**KIRKLEES METROPOLITAN COUNCIL
INVESTMENT & REGENERATION SERVICE**

Reference No:	2024/62/91277/E
Site Address:	3, Field Head, Shepley, Huddersfield, HD8 8DR
Description:	Erection of two storey side and single storey rear extensions with associated alterations
Recommending Officer:	Edward Cheseldine

HOUSEHOLDER DELEGATED REPORT

Rear Elevation - North East

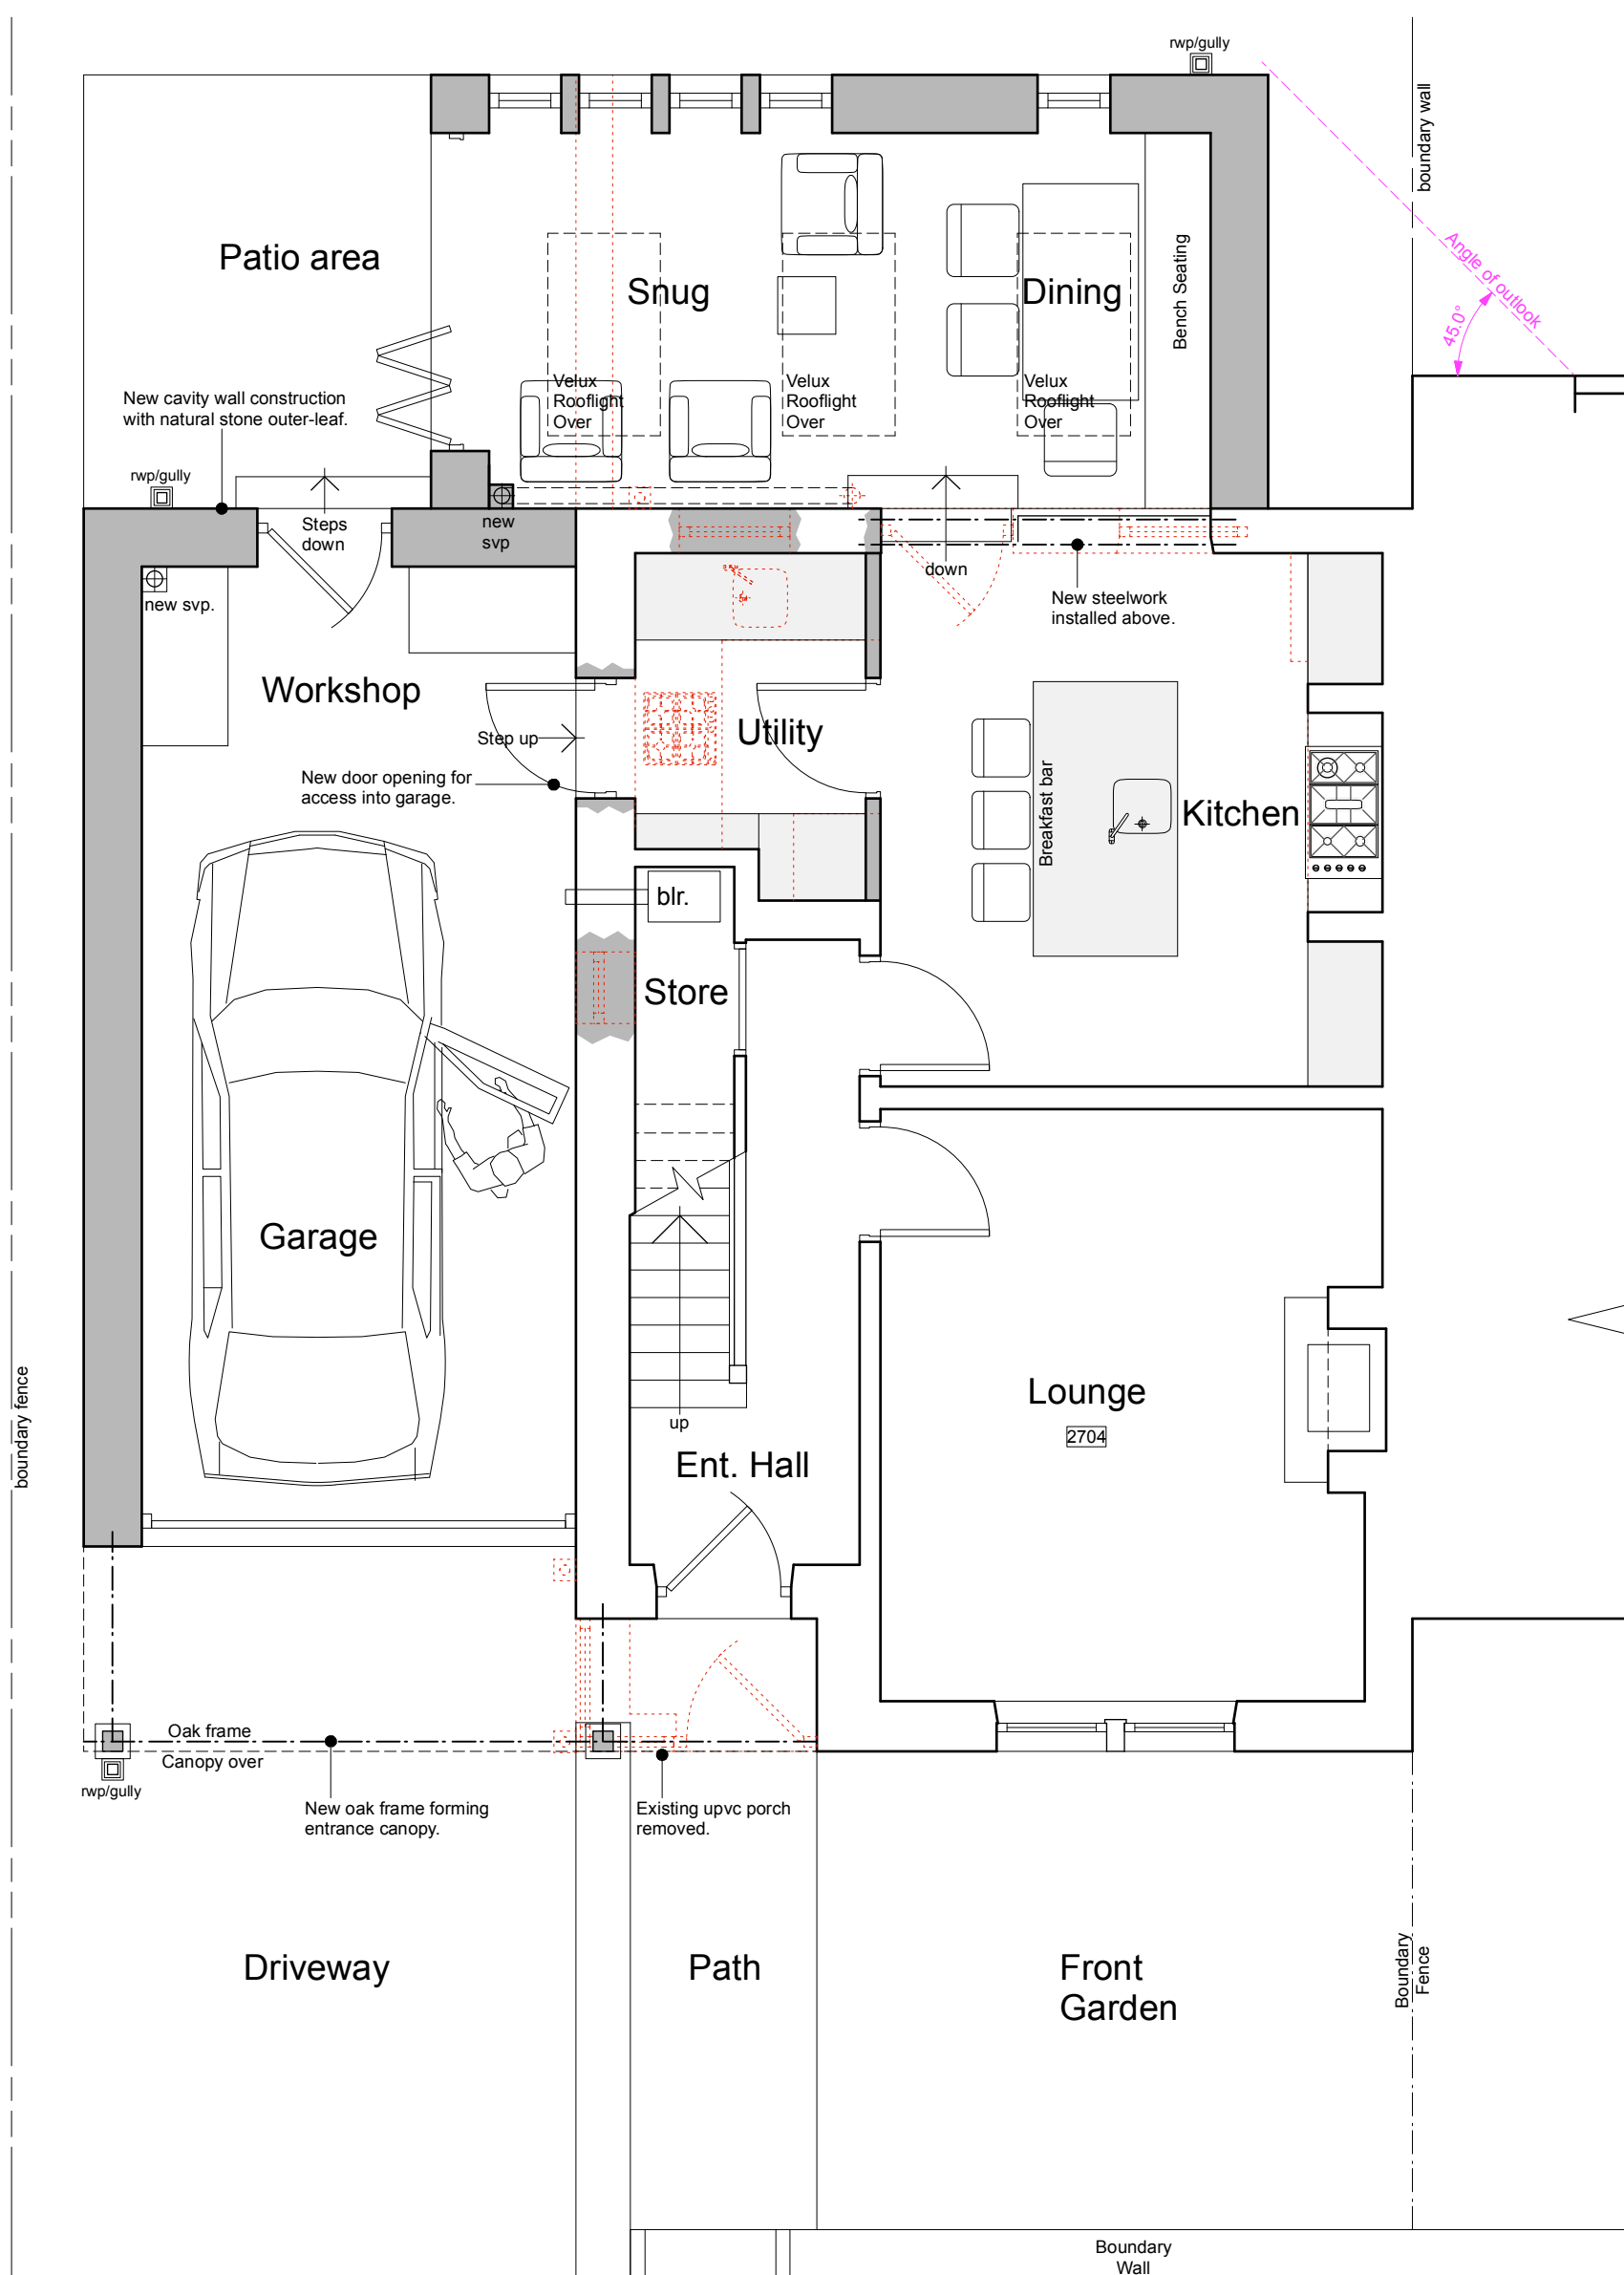
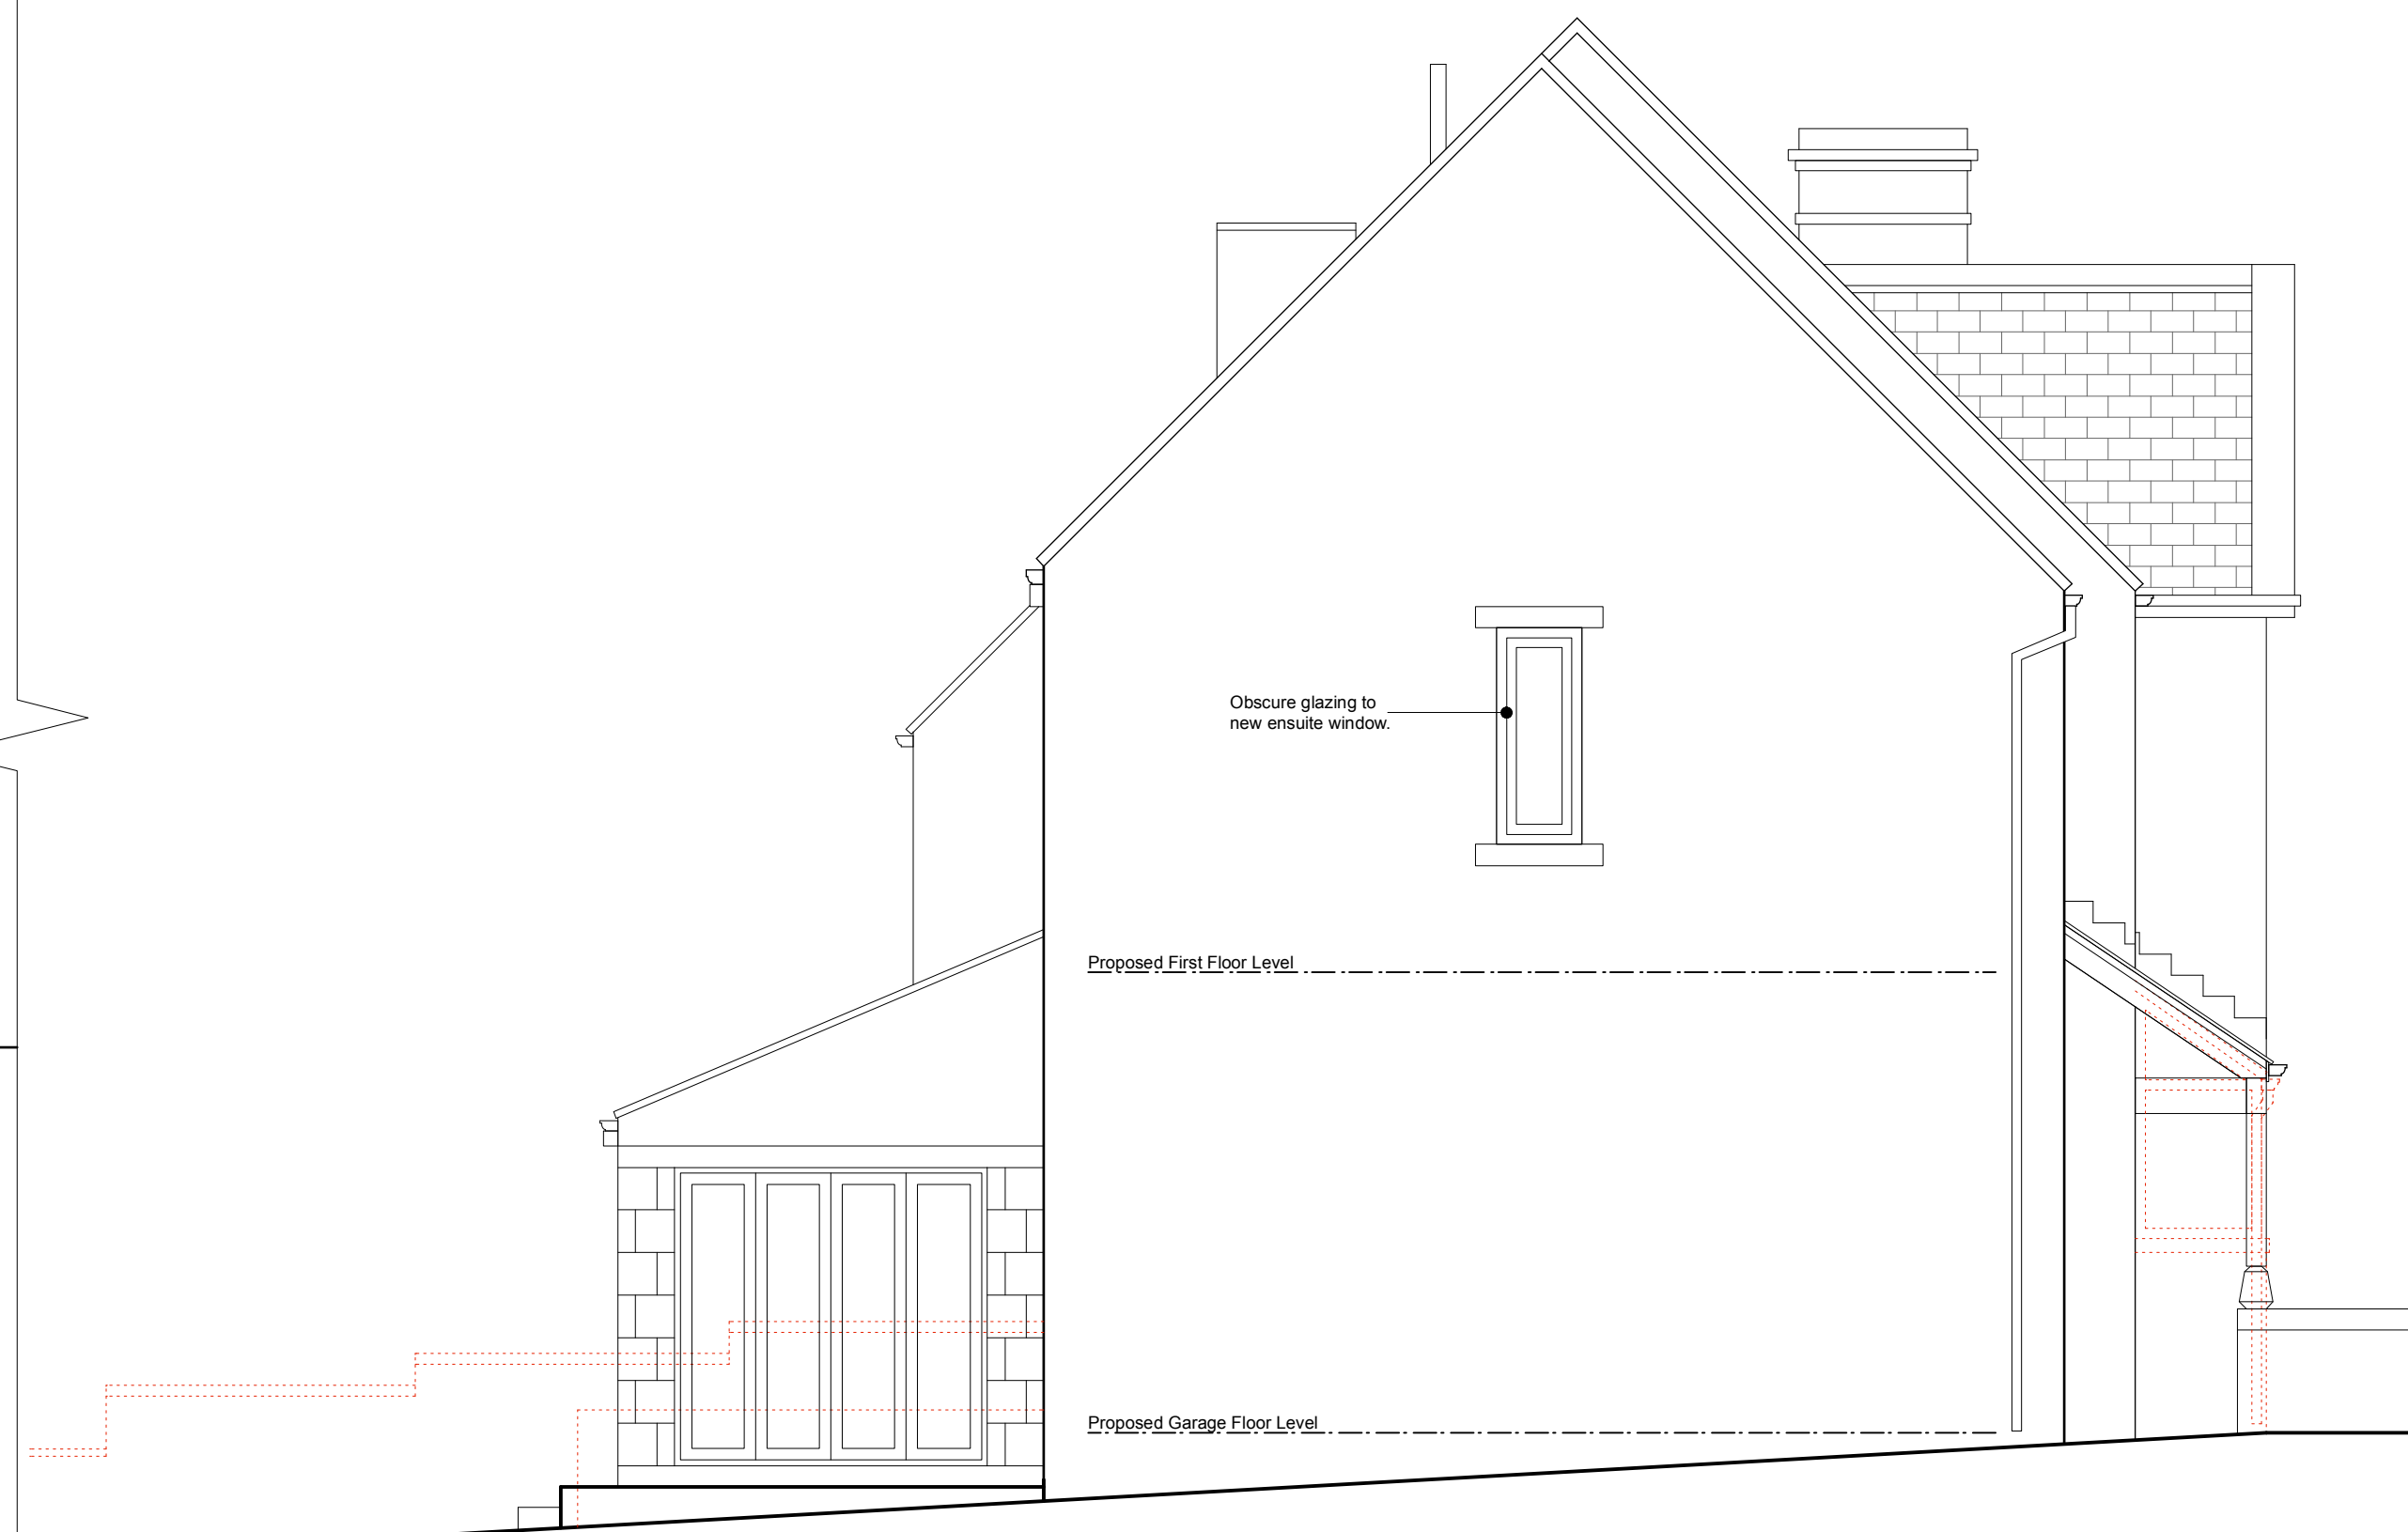
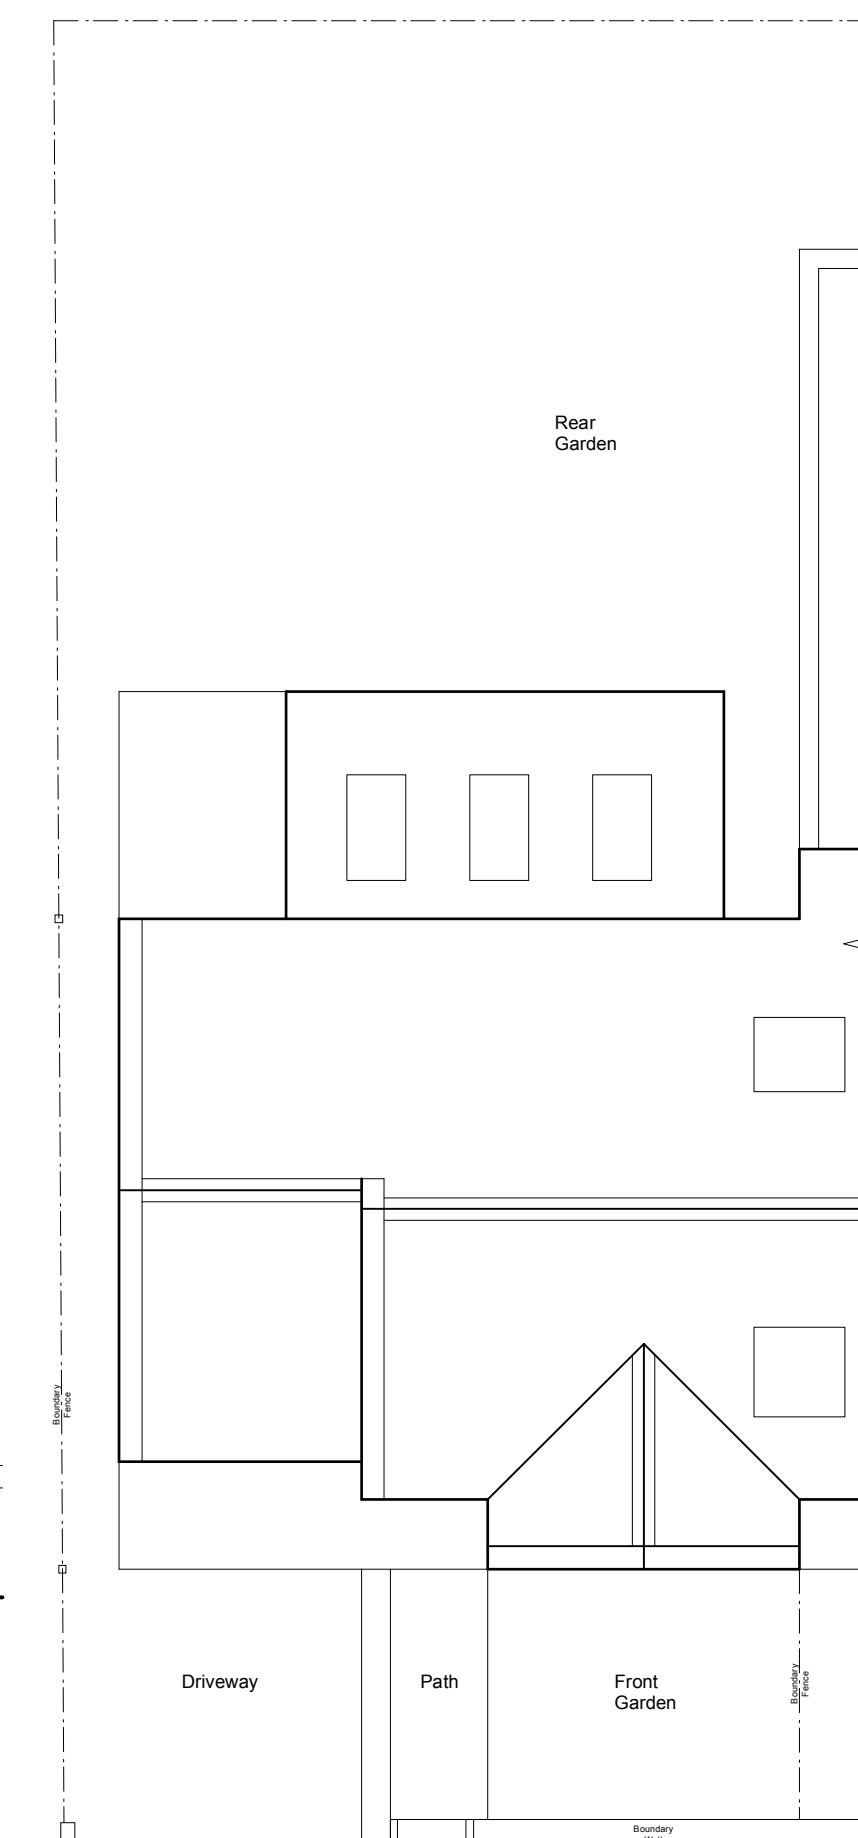
YES / NO	SUMMARY
Negotiations/Amendments during course of application		Yes, request for amended plans or to justify as per paragraph 1.11 of the House Extensions and Alterations Supplementary Planning Document as the plans did not accord to guidance set out in the design codes document. Amendments: Rear extension set in by ~1.00m to allow for 45oC

angle of outlook for neighbouring property. Side extension set back by ~0.50m. Ridgeline of side extension set down by ~0.35m. Justification for spacing to the side of the property: ~0.5m retained. Internal space required for garage. Rear door added to allow for access to the rear.
Parish/Town Council comments sought	Kirkburton Parish Council	No comment.
Relevant Planning History		<u>Application site</u> – None <u>1 Field Head</u> - 2021/93277 – Single-storey rear extension – Full permission granted
Consultations required	None

Amendments: Rear extension set in by ~1.00m to allow for 45oC angle of outlook for neighbouring property.

Side extension set back by ~0.50m.

Ridgeline of side extension set down by ~0.35m.
